**Hinckley & Bosworth Borough Council**  
**Interested Party Reference Number: 20039546**

**Deadline 4 Submission:**

**Response to Deadline 3 Submissions:**

**Application by Tritax Symmetry (Hinckley) Limited for an Order Granting  
Development Consent for the Hinckley National Rail Freight Interchange**

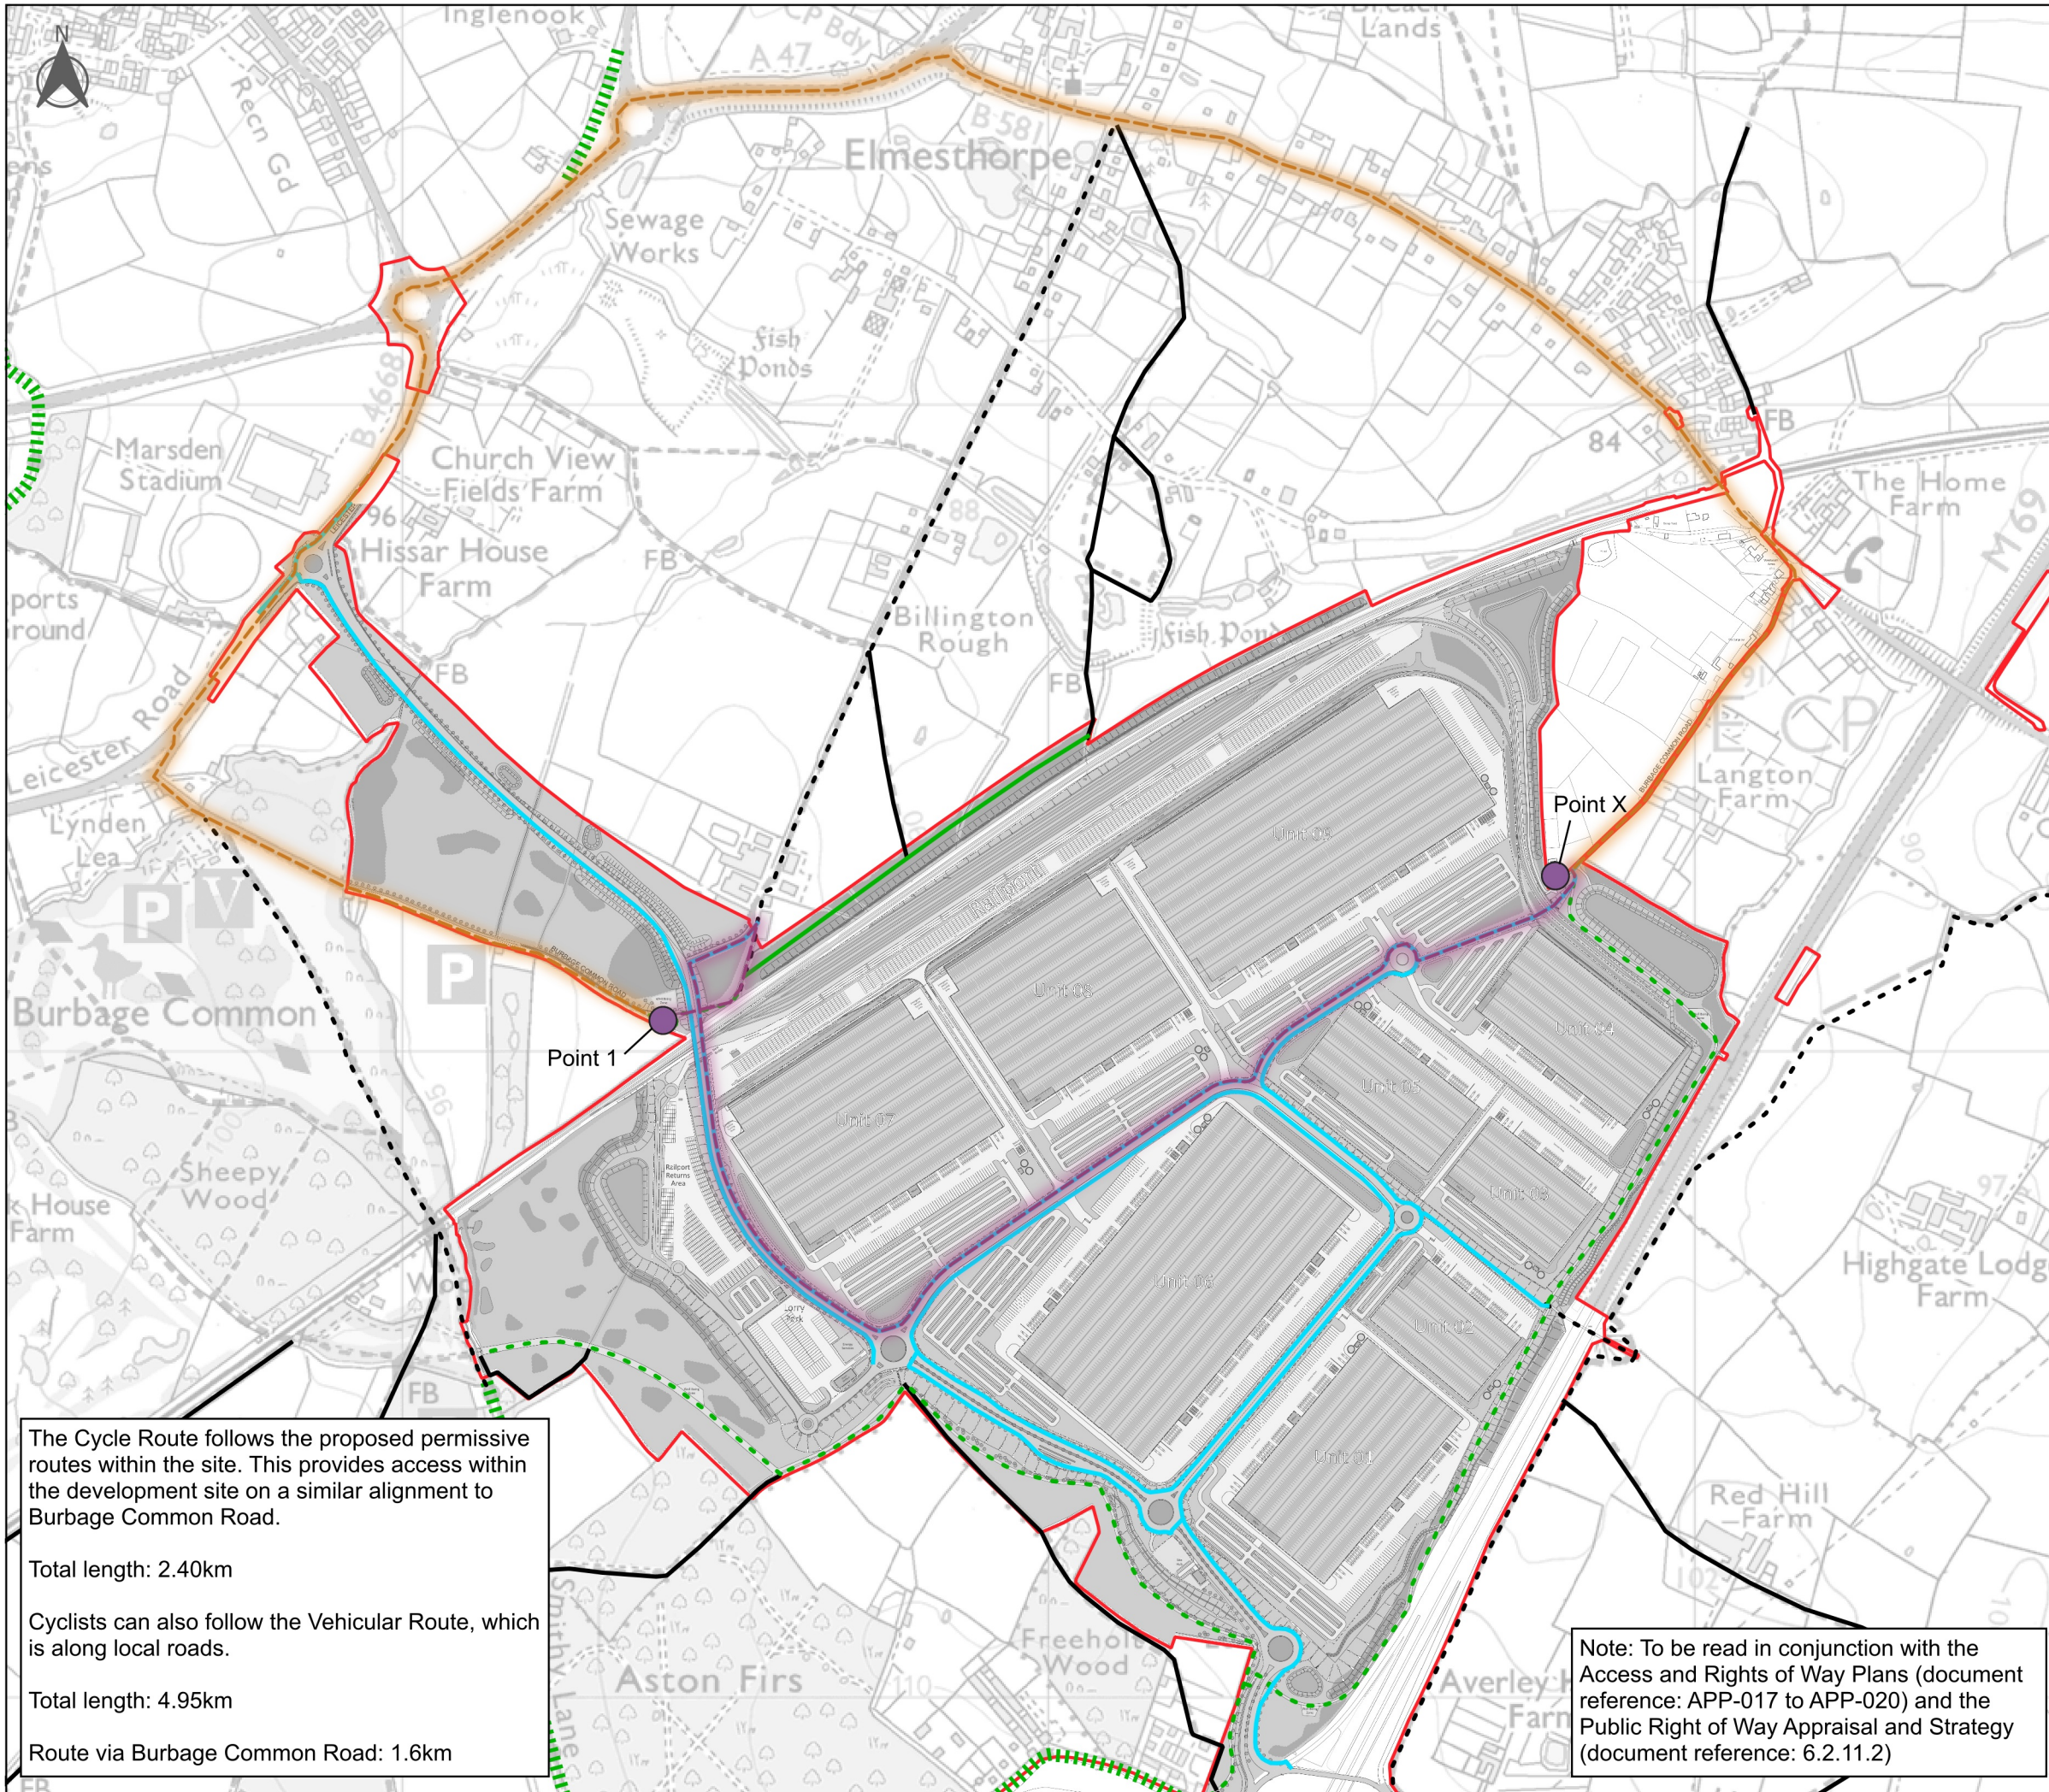
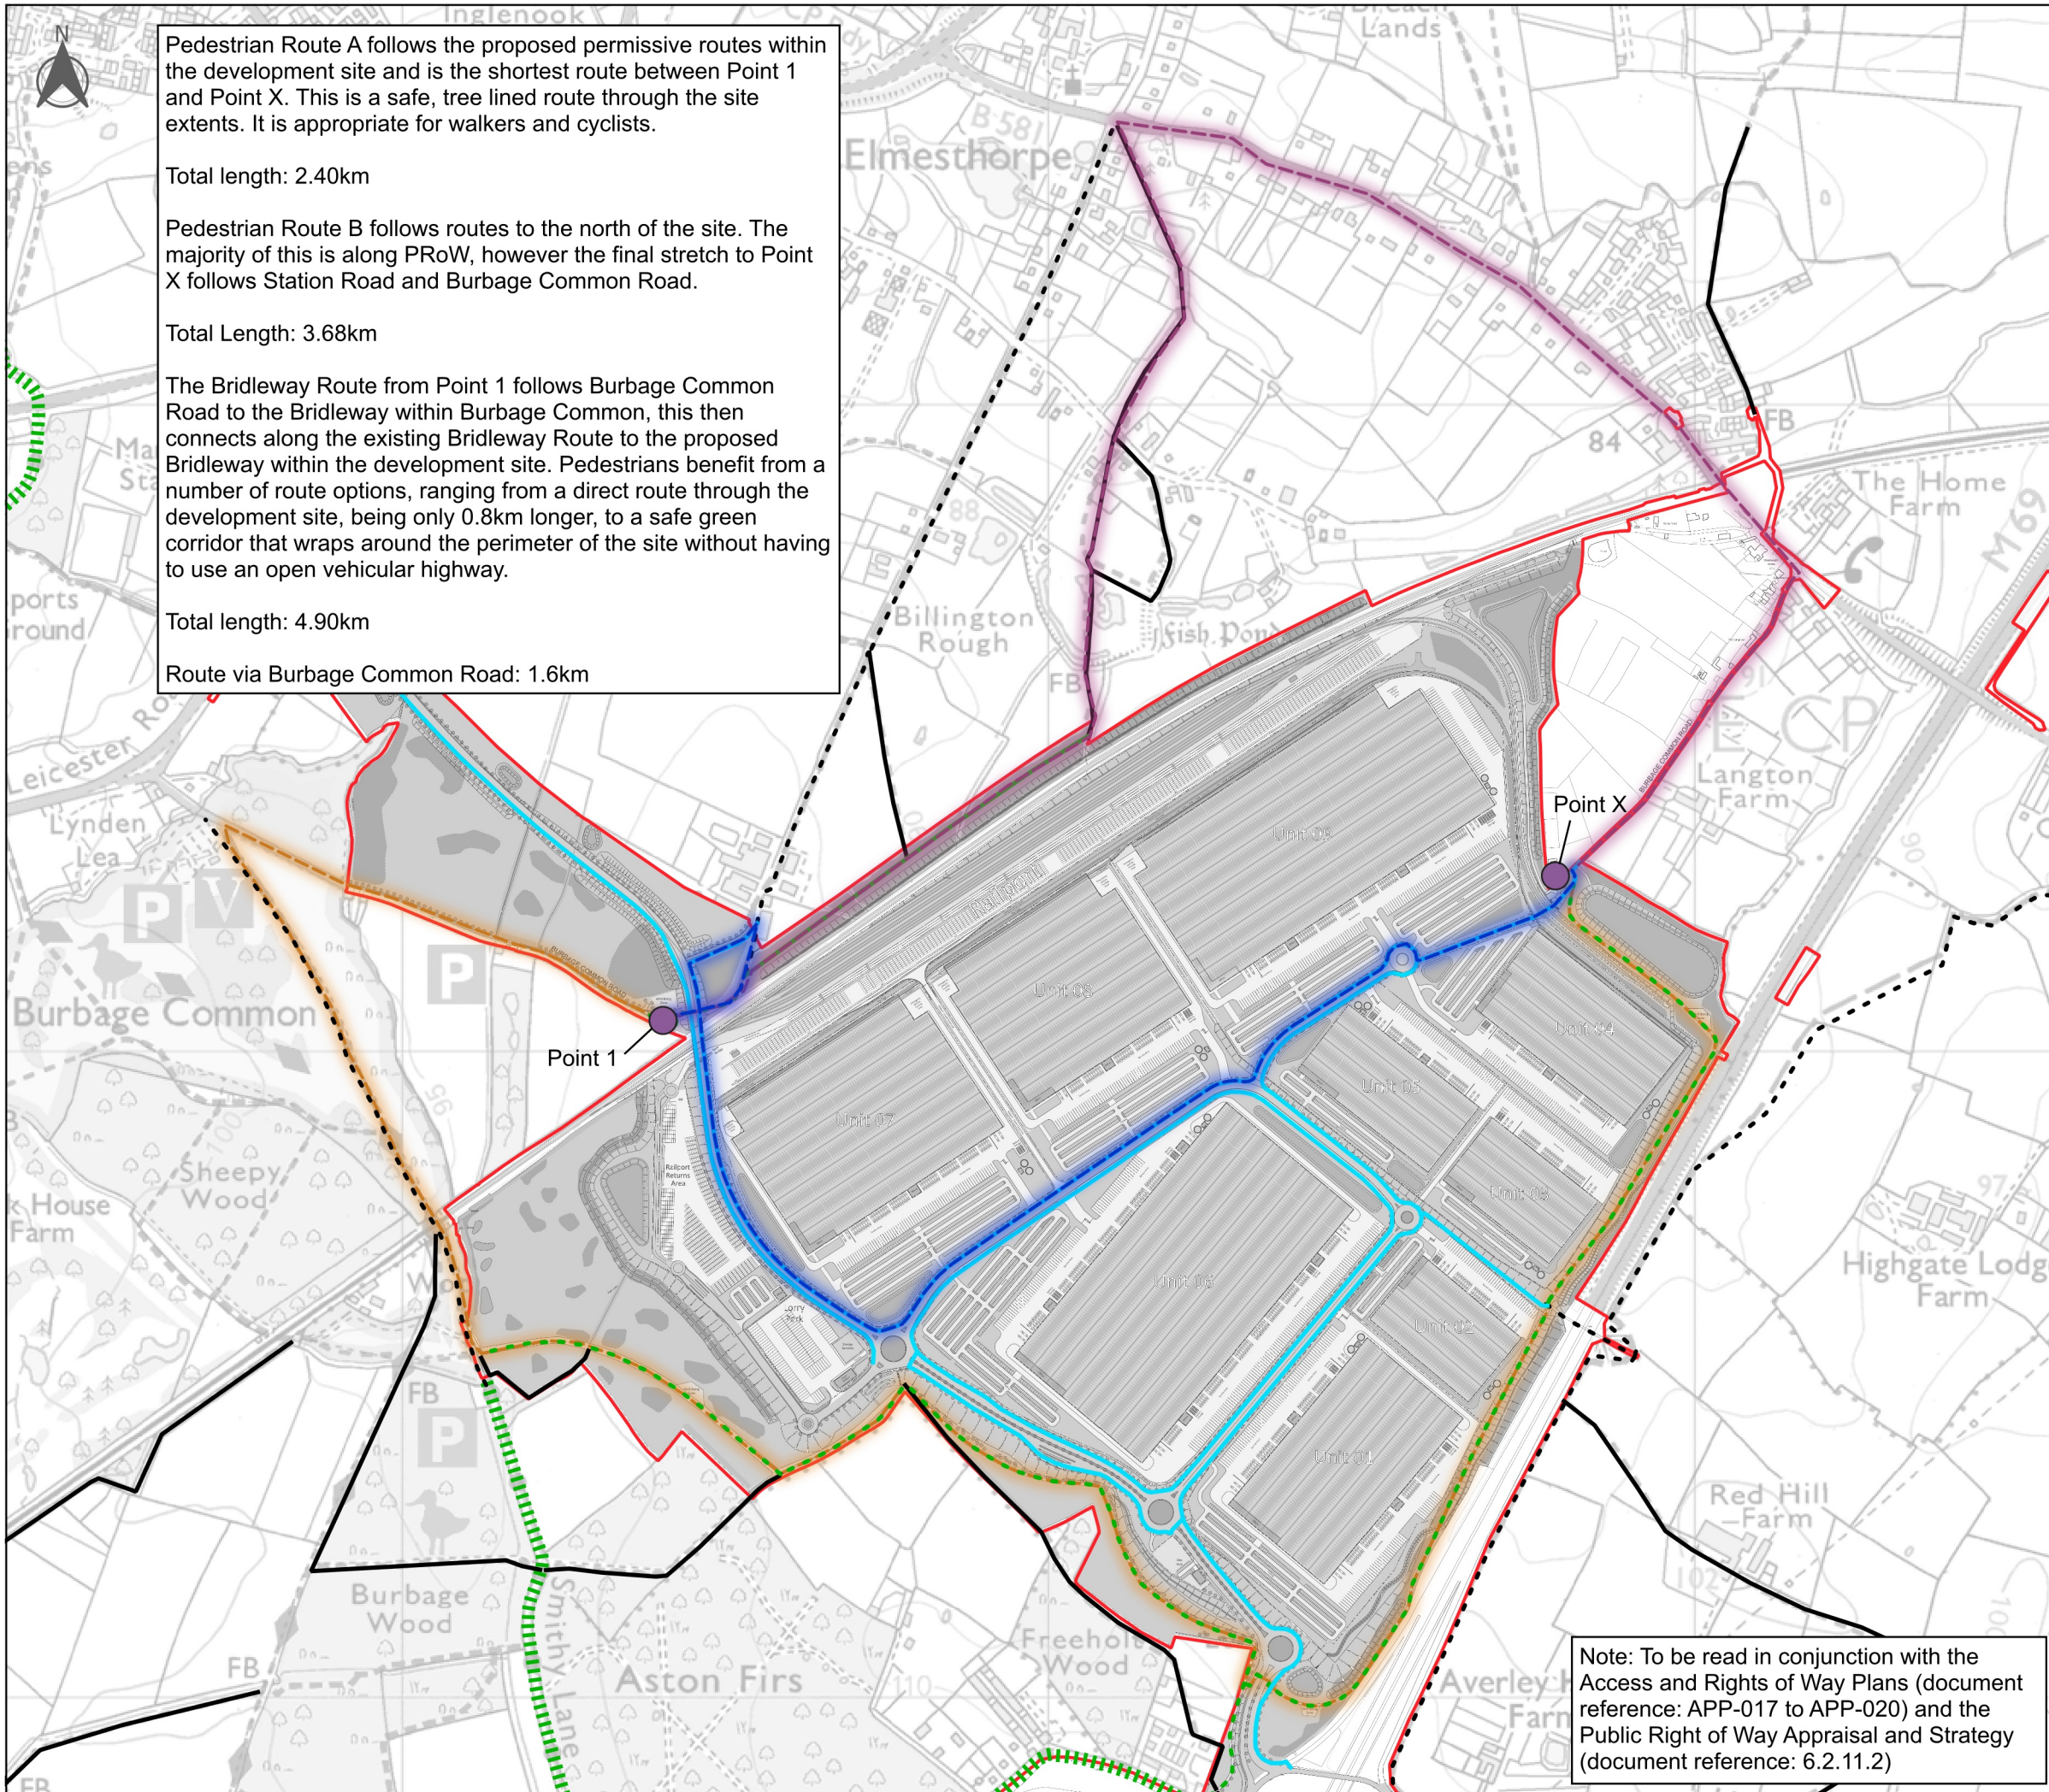
<b>REP3 – 054 – Accessibility Plans for Burbage Common Road</b>	The accessibility plans for walking and cycling appear incorrect and thus confusing. For example they show a ‘proposed permissive path’ for walkers and cyclists along the A47 – but the Council would expect these to be part of the publicly adopted highway and thus, not permissive paths. The council has expressed concern at details of these routes including the

need to cross the link road in path continuity and how safe and what quality the permissive paths will be across the site as well as crossing facilities - these concerns remain.
<b>REP3 – 018 – Framework Travel Plan</b>	
Page 21	There are some anomalies which require correction between the description of existing bus services in the sustainable transport strategy and the Travel plan, such as the service 8
Page 28	<p>It is not clear which of the elements listed here from the Sustainable Transport Strategy (STS) will be implemented by the applicant and when; and what in what detail (such as the cycling improvements). As noted in the separate comments in relation to the STS, the bus proposals appear minimal with no detail of the catchments, journey and walking times relating to the proposals. The Travel Plan only appears to commit to the X6 service, an extension of the 8 service and relatively unspecified DRT provision. These elements need to be further described and detailed to be meaningful measures in the Travel Plan that can be secured and monitored.</p> <p>As one example, in respect of bus service 8 (Hinckley Nuneaton), table 6 in the STS describes a potential option; there is no plan of the proposed route and stops, the stop catchments and service journey time, including walk to/from bus stops ( or interchange with described internal shuttle bus ) . It is not quite clear the timings of the service and days of week of operation although it seems to be a 1 per hour proposal. Without this information it is difficult to understand whether this service will provide good accessibility and how it can be secured.</p>
